To: Amber Willard <[REDACTED]>
Subject: RE: fp/159/20/pun

I attach the plans for proposed extension to the neighbouring property at 36 Blackthorn Avenue.

SITE PLAN 1:500

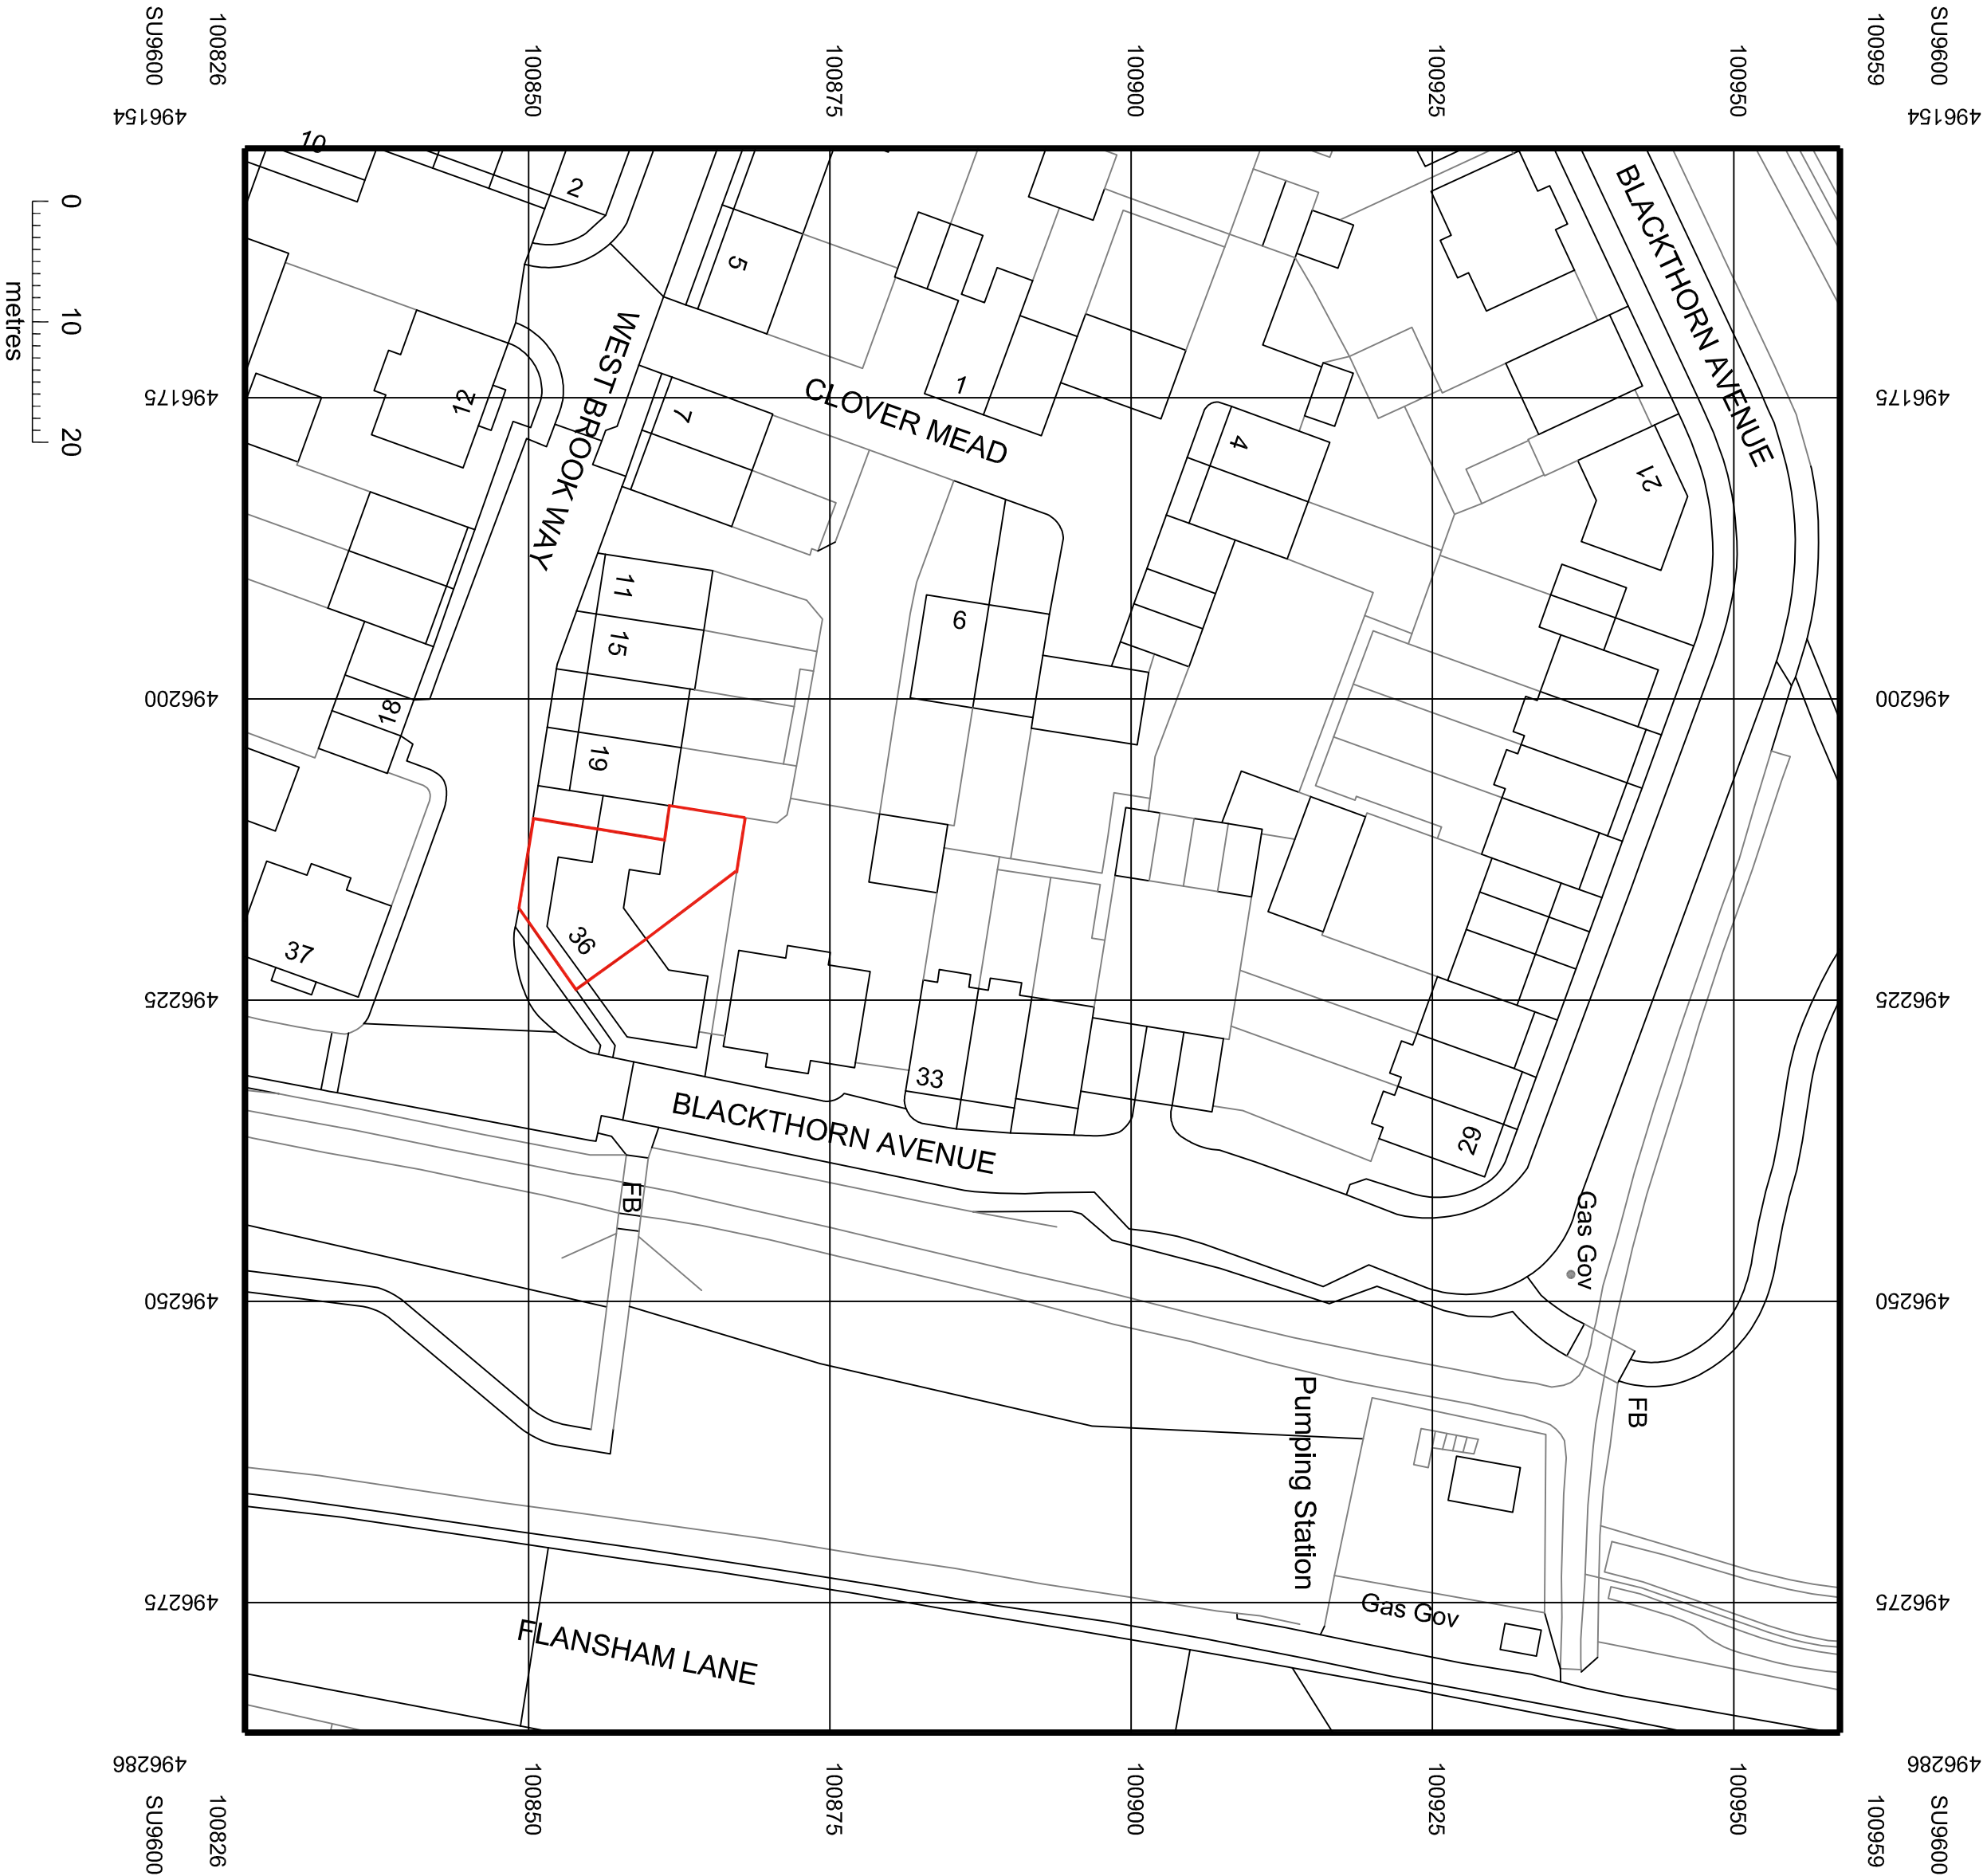
Thank you for the prints of the above Planning Application. We also had problems getting it to print, in fact we couldn't get the site plan to print at all and as that is the most important aspect we were very glad to receive the copy that you sent us, it arrived on Saturday.

I note that the relationship with our house next door is difficult to judge as very little of it is shown on the plans submitted. In fact the all important eastern elevation of the proposed extension is not shown at all. You can see that our number 35 Blackthorn Ave., is on the inside of a 90 degree bend in the road and is therefore a tiny triangle of back garden with the adjacent boundaries joining at the bottom of the triangle. The boundary between number 35 and 36 does not run away from us parallel to our house, it comes diagonally across our rear garden and if the proposed extension to number 36 was built we would be looking out at an 11ft high brick wall across our line of sight.

STATUS		APPLICATION	
REV	DESCRIPTION	DATE	20/08/20
CLIENT			
MR GILBERTO & MISS NUNN			
PROJECT			
36 BLACKHORN AVENUE			
FELPHAM			
PO22 8GA			
DRAWINGS			
PROPOSED PLANS & ELEVATIONS

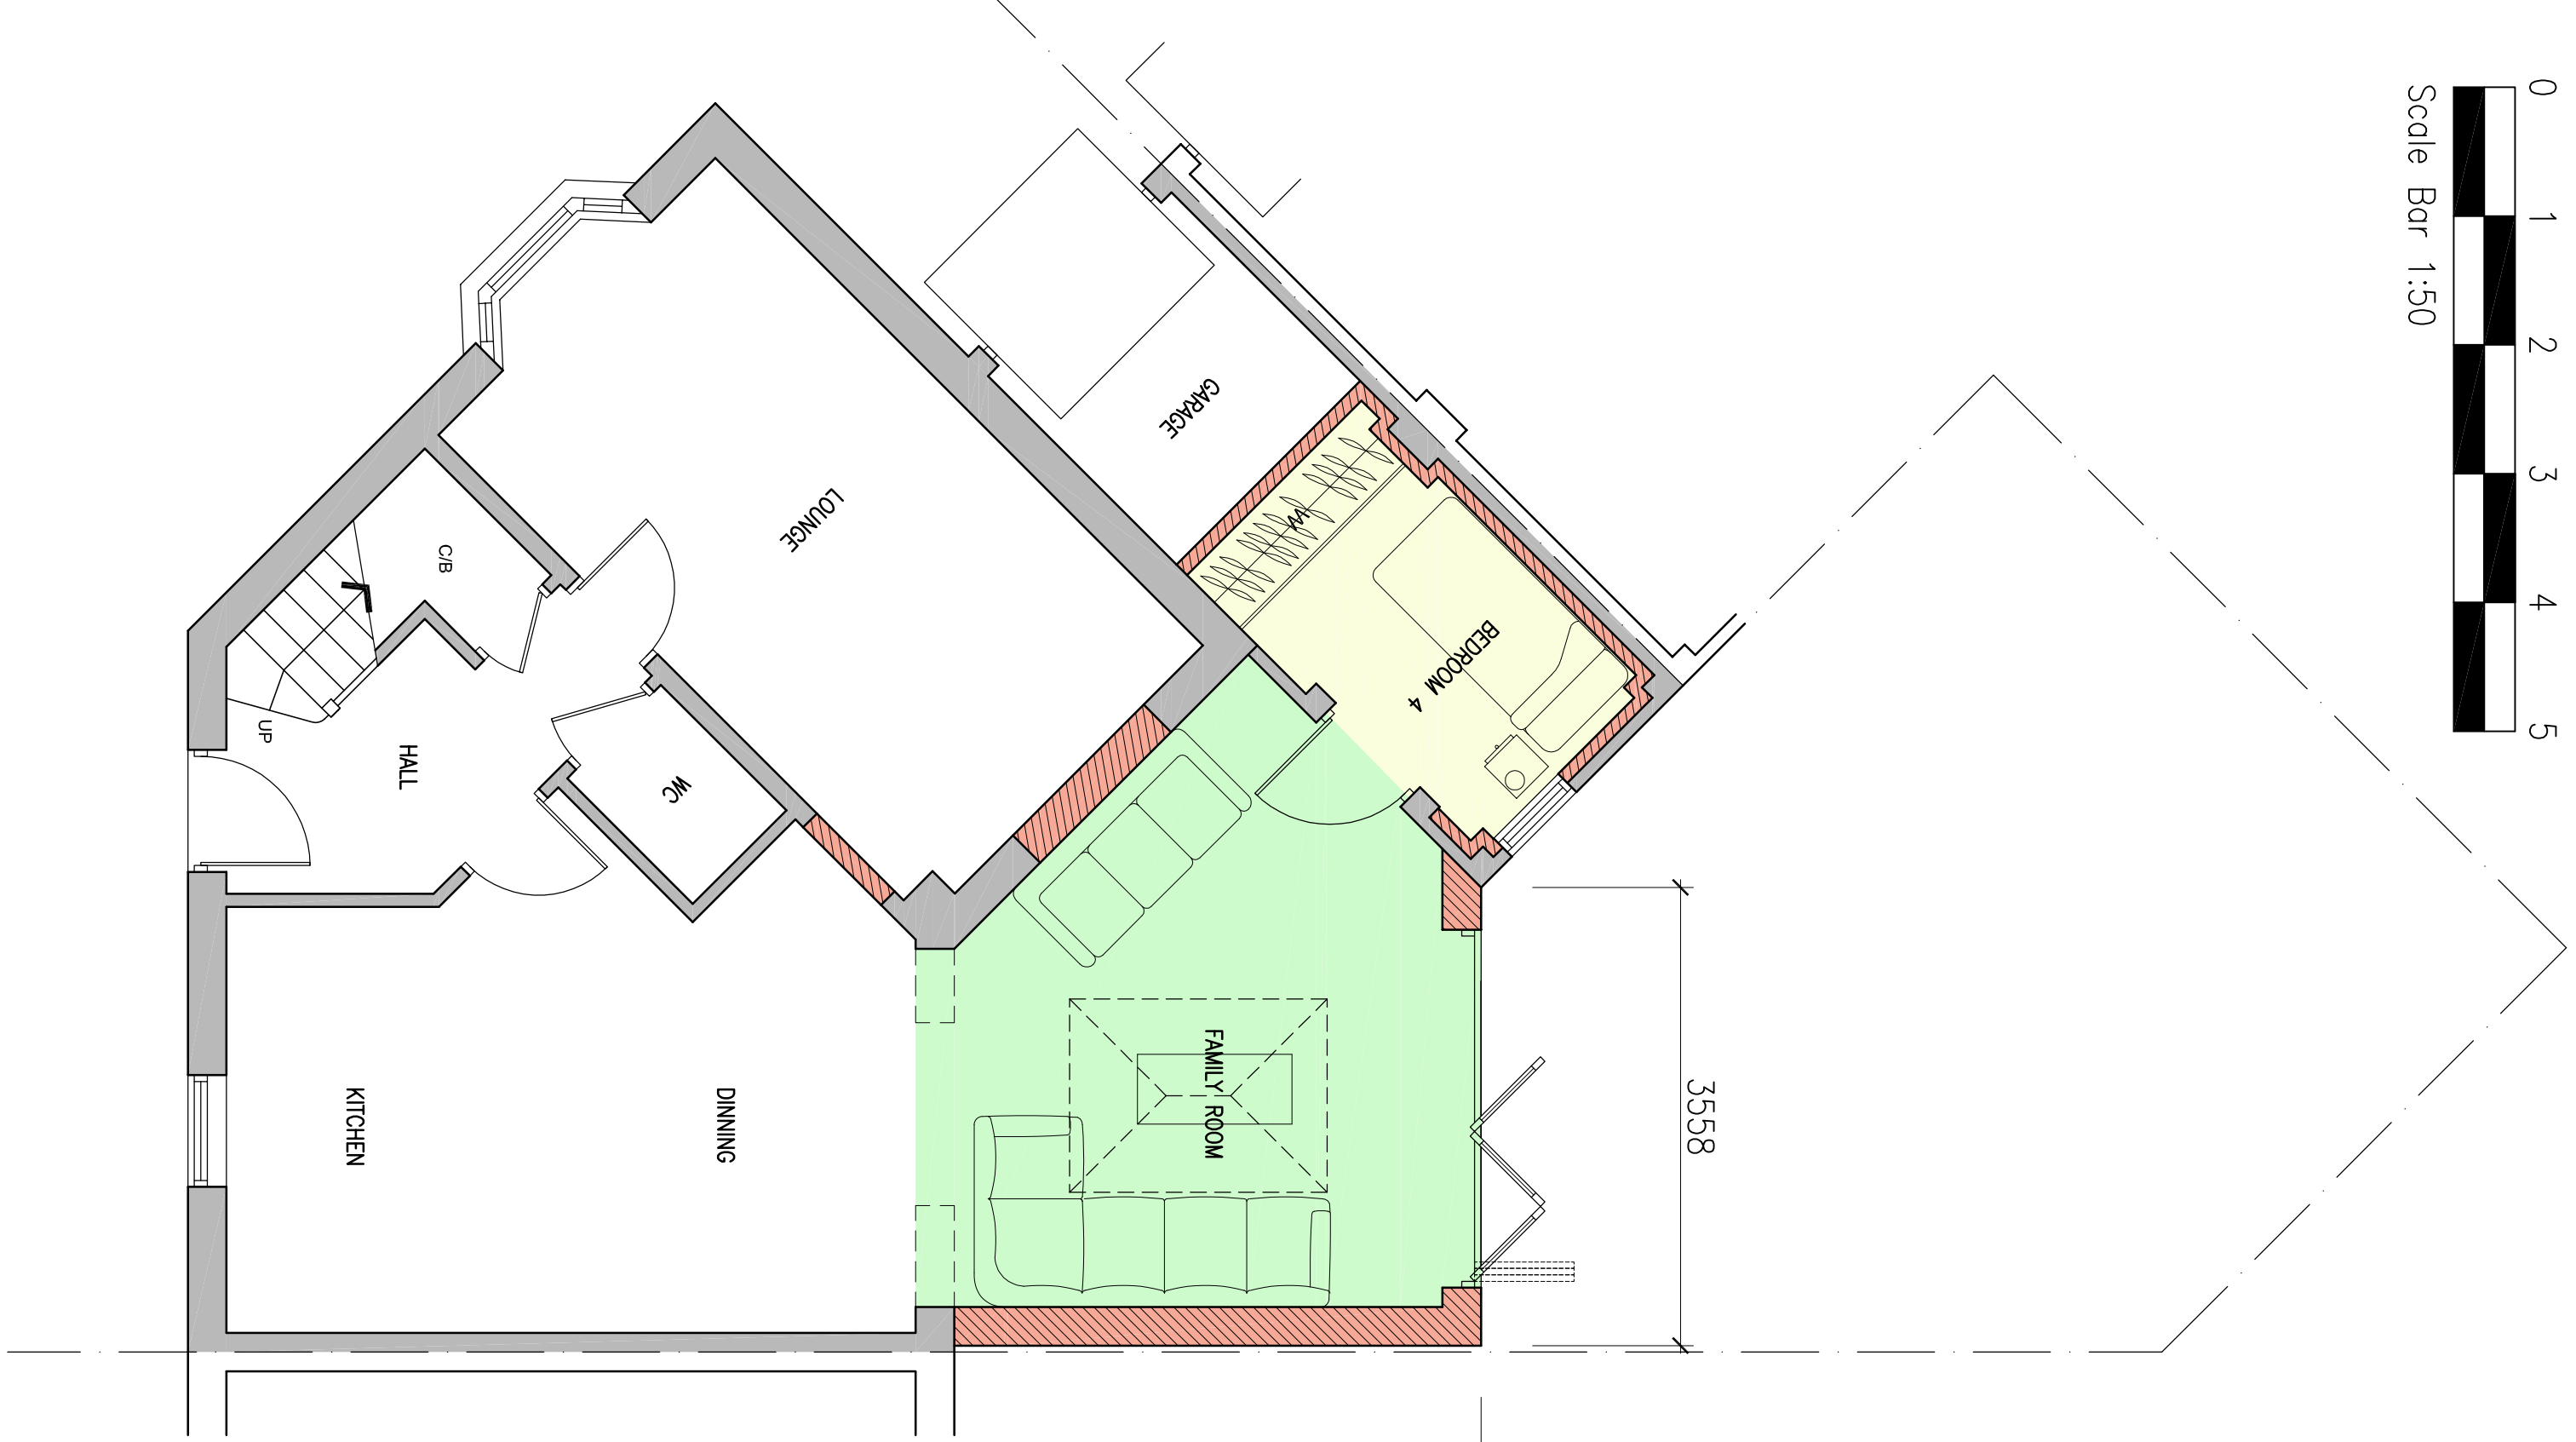
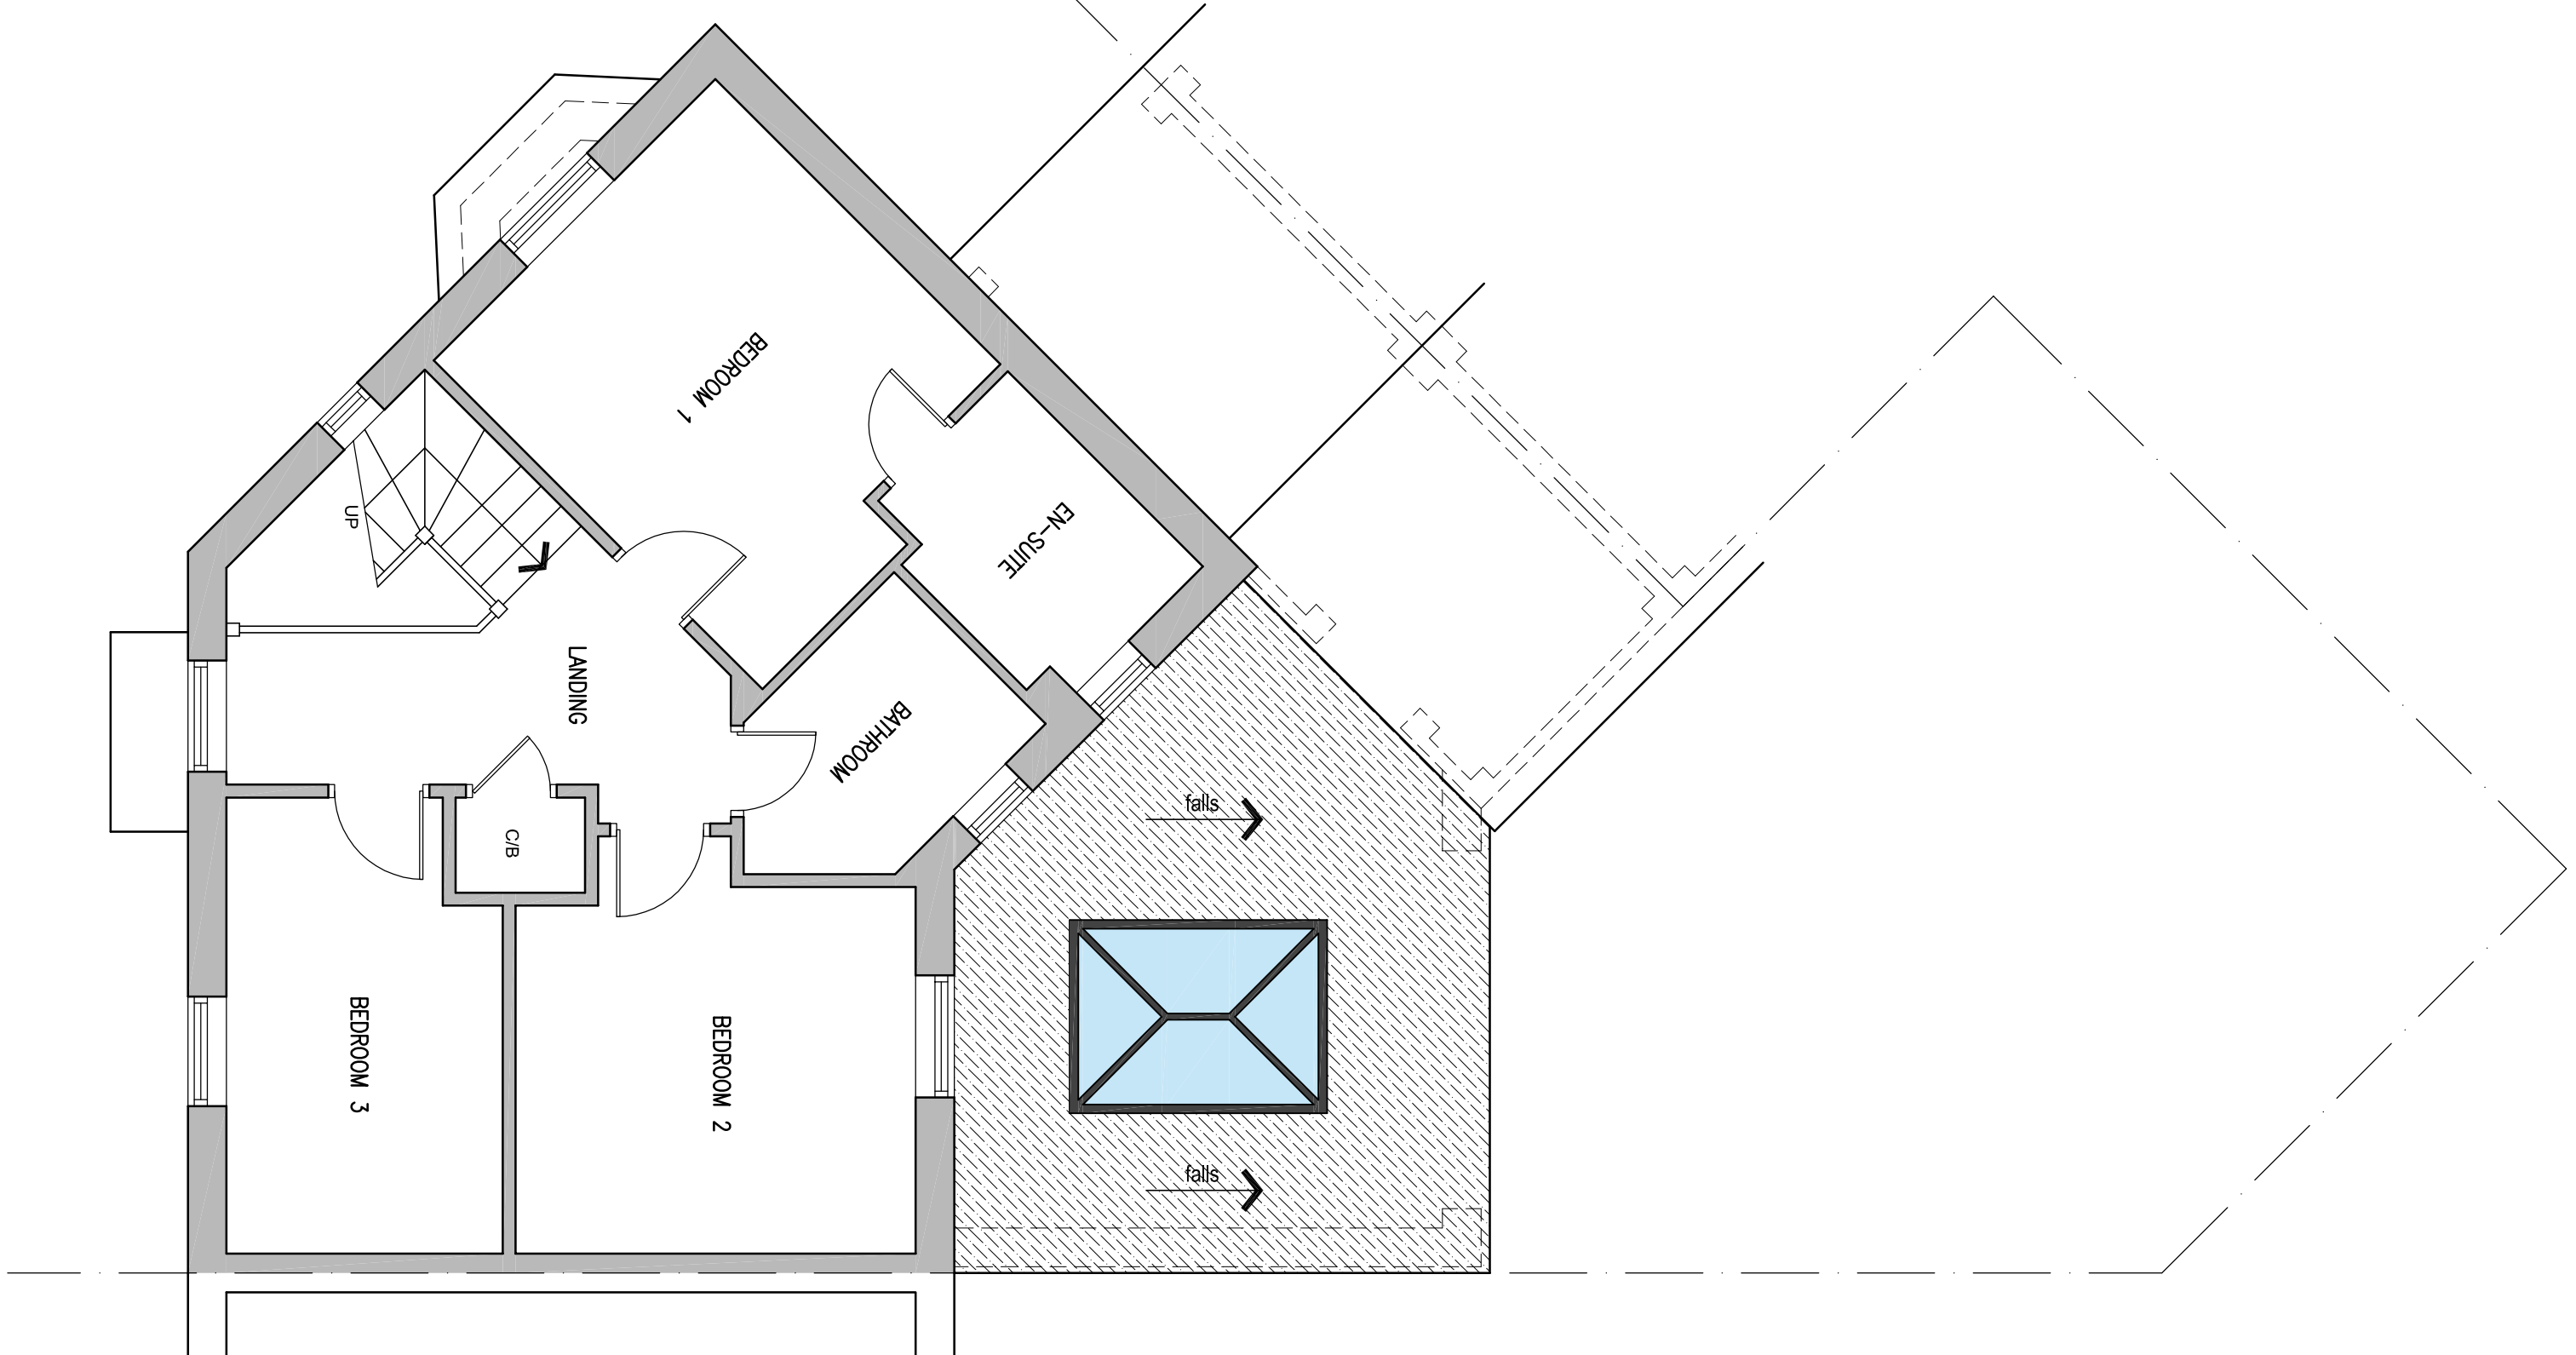
Nobody would want to live there hemmed in by a 3m (11 foot) high 4.092m (12ft long) brick wall. Perhaps you could let us know whether there are regulations concerning degrees of sightlines from our windows that are protected?
